WEST SUSSEX COUNTY COUNCIL CONSULTATION

TO:	Arun District Council FAO:Zac Denton
FROM:	WSCC - Highways Authority
DATE:	8 April 2019
LOCATION:	Land to rear of 141 Wick Street Littlehampton BN17 7JY
SUBJECT:	LU/84/19/PL 1 New dwelling on land rear of 141 Wick Street.
DATE OF SITE VISIT:	n/a
RECOMMENDATION:	Advice
S106 CONTRIBUTION TOTAL:	£n/a

Rev.	Notes	Date
nat design 23 Mill Road Angmering, West Sussex BN16 4HT www.nat-design.co.uk		
Project Land to the rear of 141 Wick Street Littlehampton West Sussex		
Drawing Proposed Site Plan with Dimensions		
Drawn By NSE		Scale as shown @ A3
Date Jan 2019		Revision -
Drawing No. 456 - DPA 06

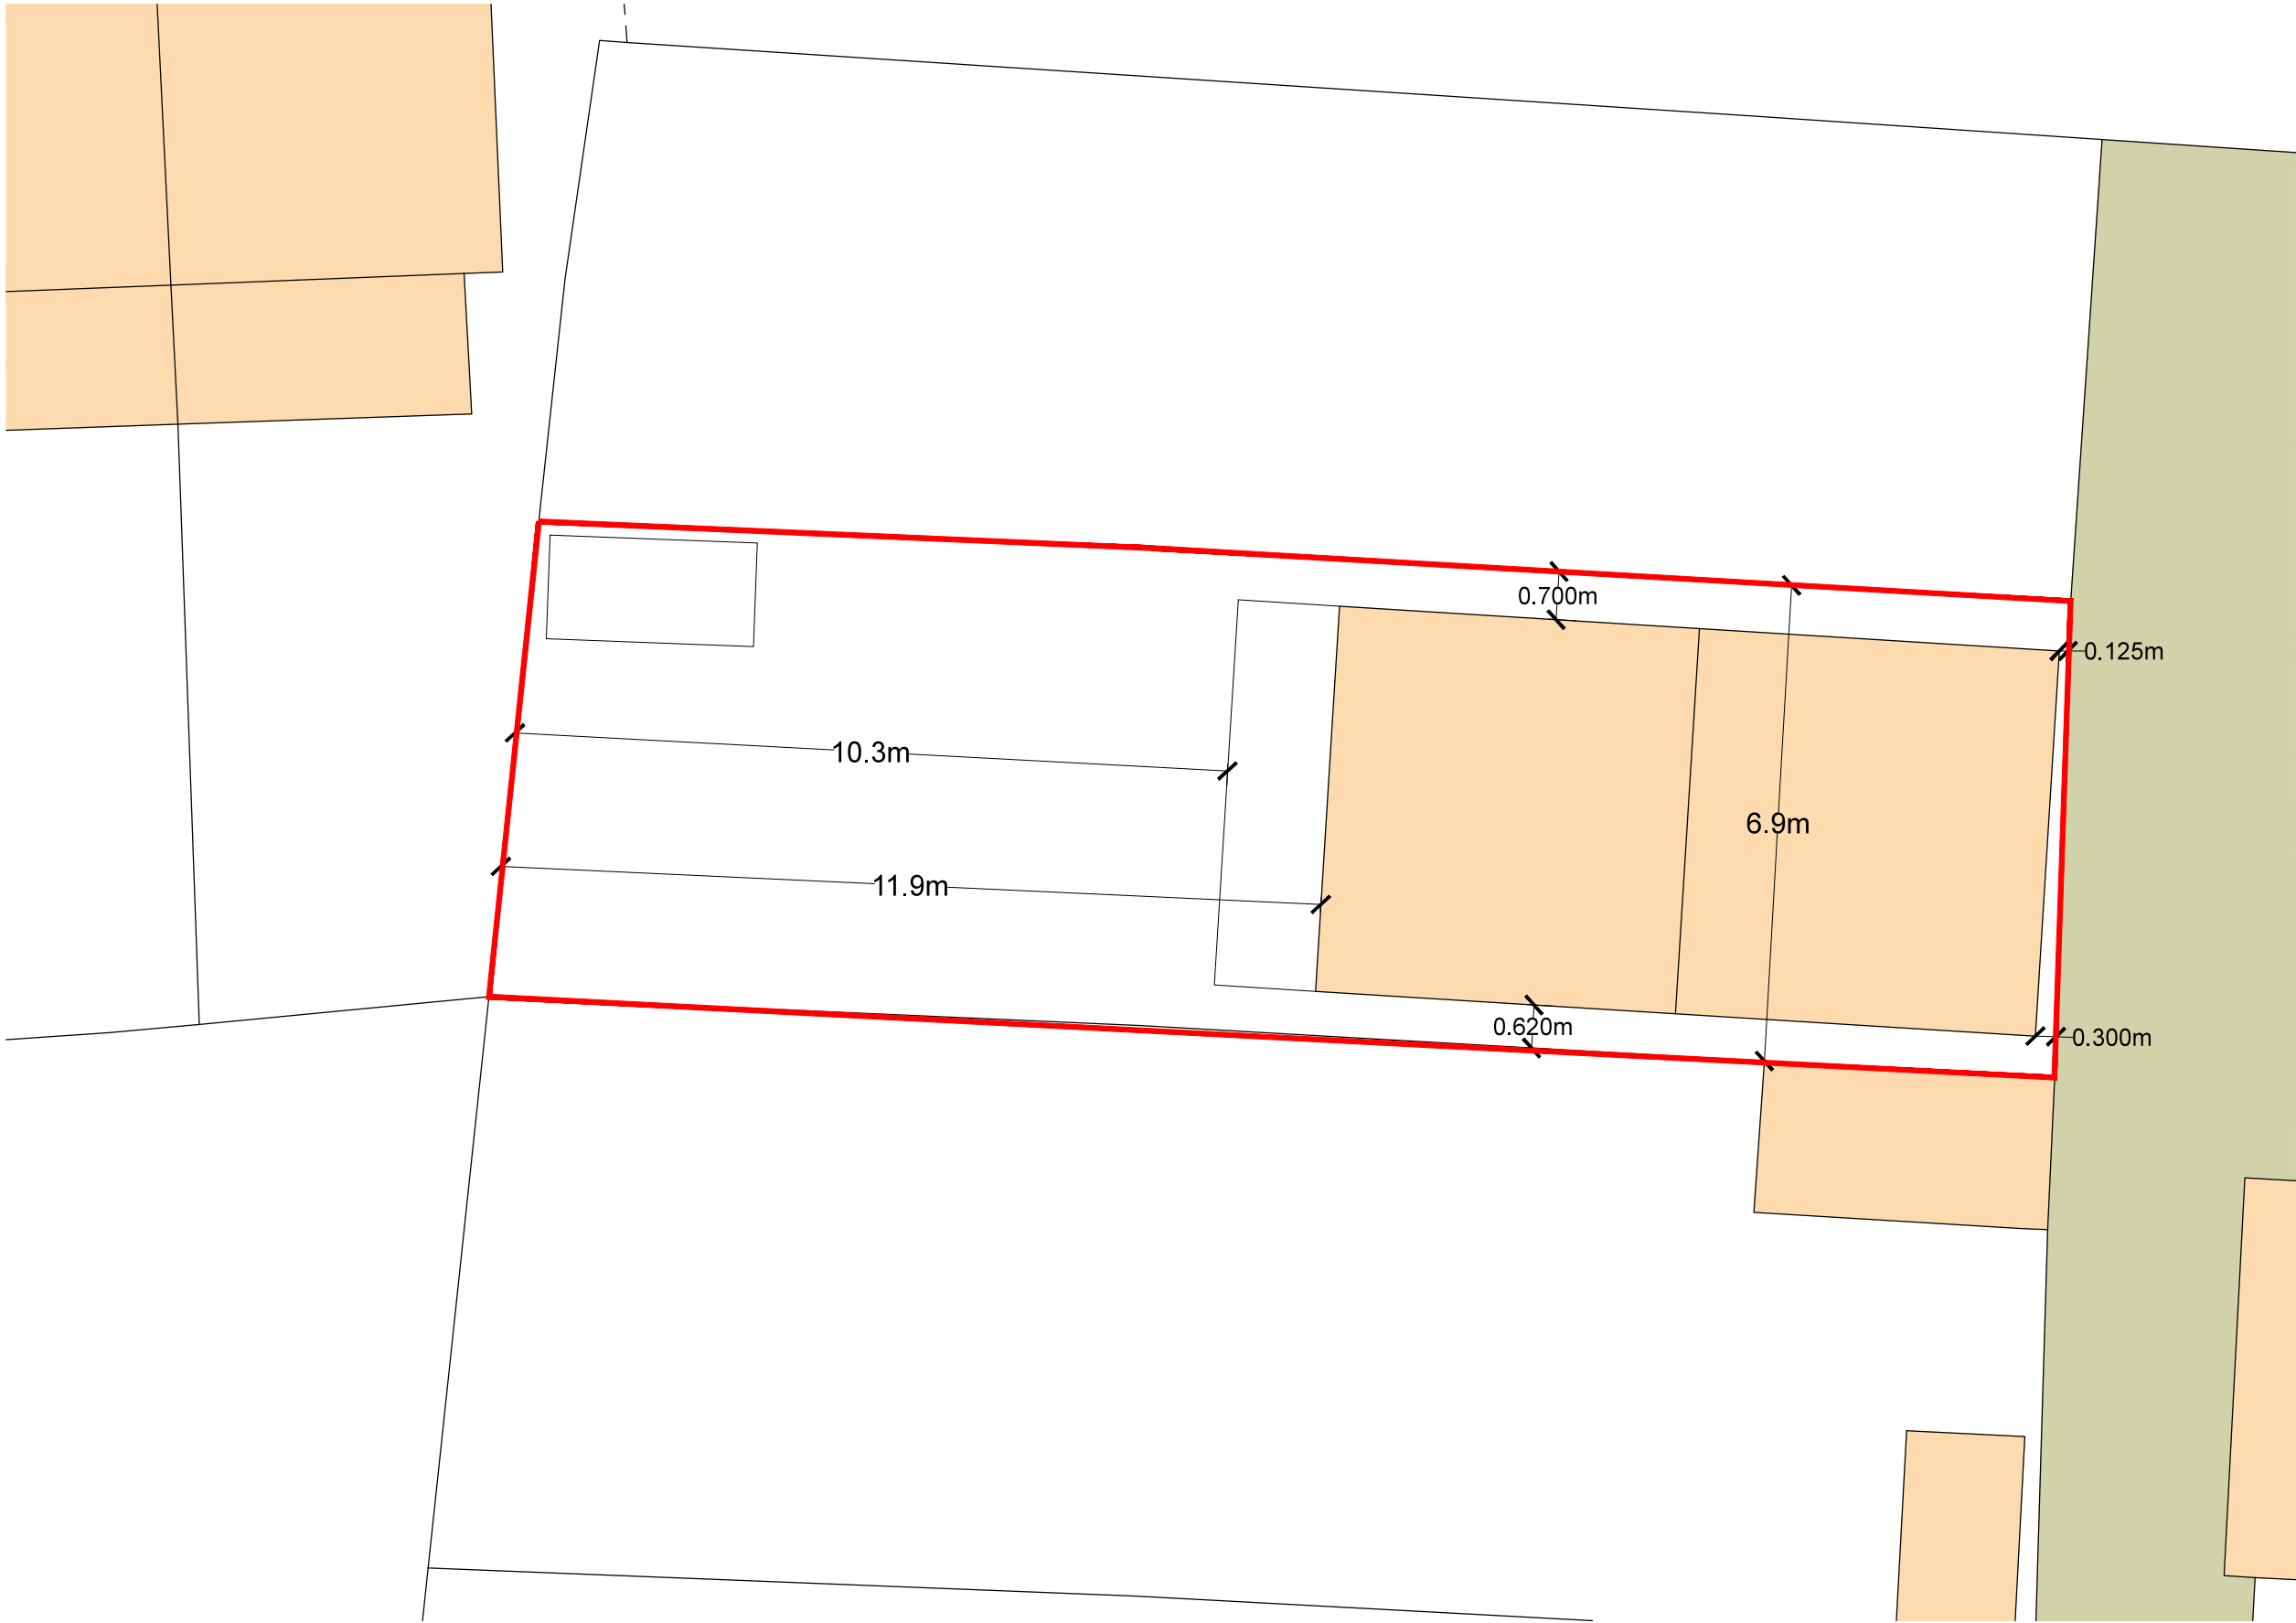
WSCC local mapping and plans show that the minimum width of the access is 2.5m. Consideration at the planning stage needs to therefore be given to emergency access and refuse collection in order to satisfy building regulations. It is appreciated that Wick Street provides access to other dwellings, which must have servicing requirements of their own. There is no indication of any waste storage or collection points on the proposed site plan. The LPA would be advised to consult with the waste collection authority to determine the suitability of any waste collection point. It should be noted

that if the preferred method of refuse collection is at the site access point onto Wick Street this would be in excess of waste carry distances as described in Manual for Streets 6.8.9.

Vehicular access for fire appliances should be available within 45m of the furthest point of each dwelling. The WSCC Water and Access Manager has been consulted on this application and has not provided comments at this stage, these will be forwarded once received. The applicant should be aware that they may need to demonstrate that a fire appliance can access, operate and turn on site in an emergency in order to meet building regulations; mitigation measures such as sprinklers may need to be installed should this not be achievable.

The site is located in a sustainable location within walking and cycling distance to a range of public services, amenities and employment options. Bus and rail links provide a realistic travel opportunity for longer trips. The Local Highways Authority (LHA) note that the applicant has shown adequate cycle storage on the plans, and this maybe secured via condition.

No part of the development shall be first occupied until covered and secure cycle parking spaces have been provided in accordance with plans and details submitted to and approved by the Local Planning Authority.

Rev.	Notes	Date
nat design 23 Mill Road Angmering, West Sussex BN16 4HT www.nat-design.co.uk		
Project Land to the rear of 141 Wick Street Littlehampton West Sussex		
Drawing Proposed Floor Plans		
Drawn By	Scale	
NSE	as shown @ A3	
Date	Revision	
Jan 2019		
Drawing No.	456 - DPA 03

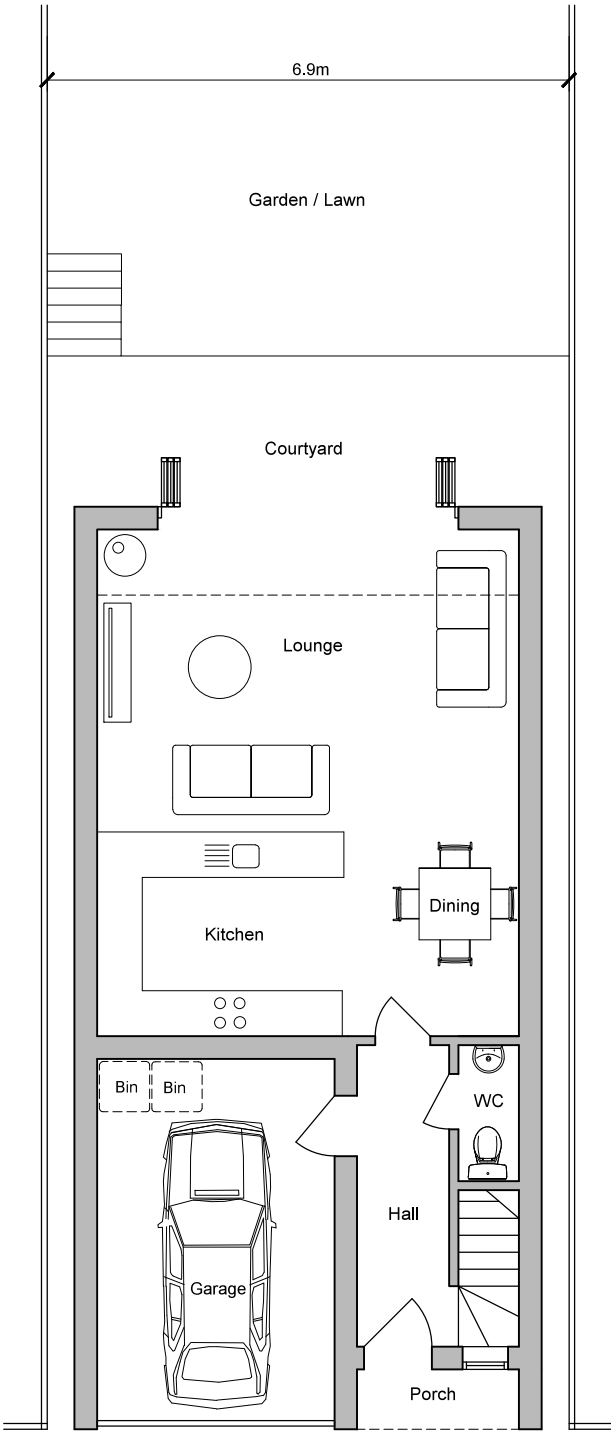
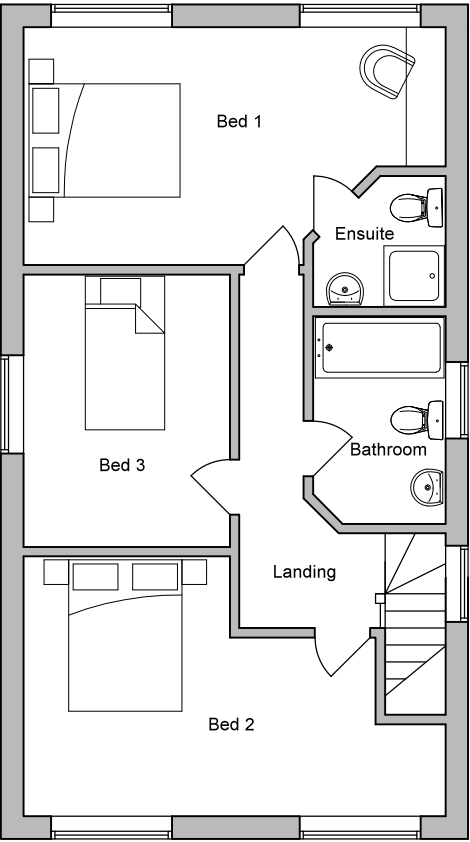
After inspection of the plans it is noted that the refuse storage will be located in the garage, although Manual for Streets does state that residents should not have to travel over 30m to put bins out and collection vehicles should not have to travel in excess of 25m to collect/deposit bins. This is however a matter of amenity for the Local Planning Authority (LPA) to consider. The applicant is advised to contact the waste disposal authorities to ascertain whether the practise would be acceptable and not require the relocation of the bin storage area.
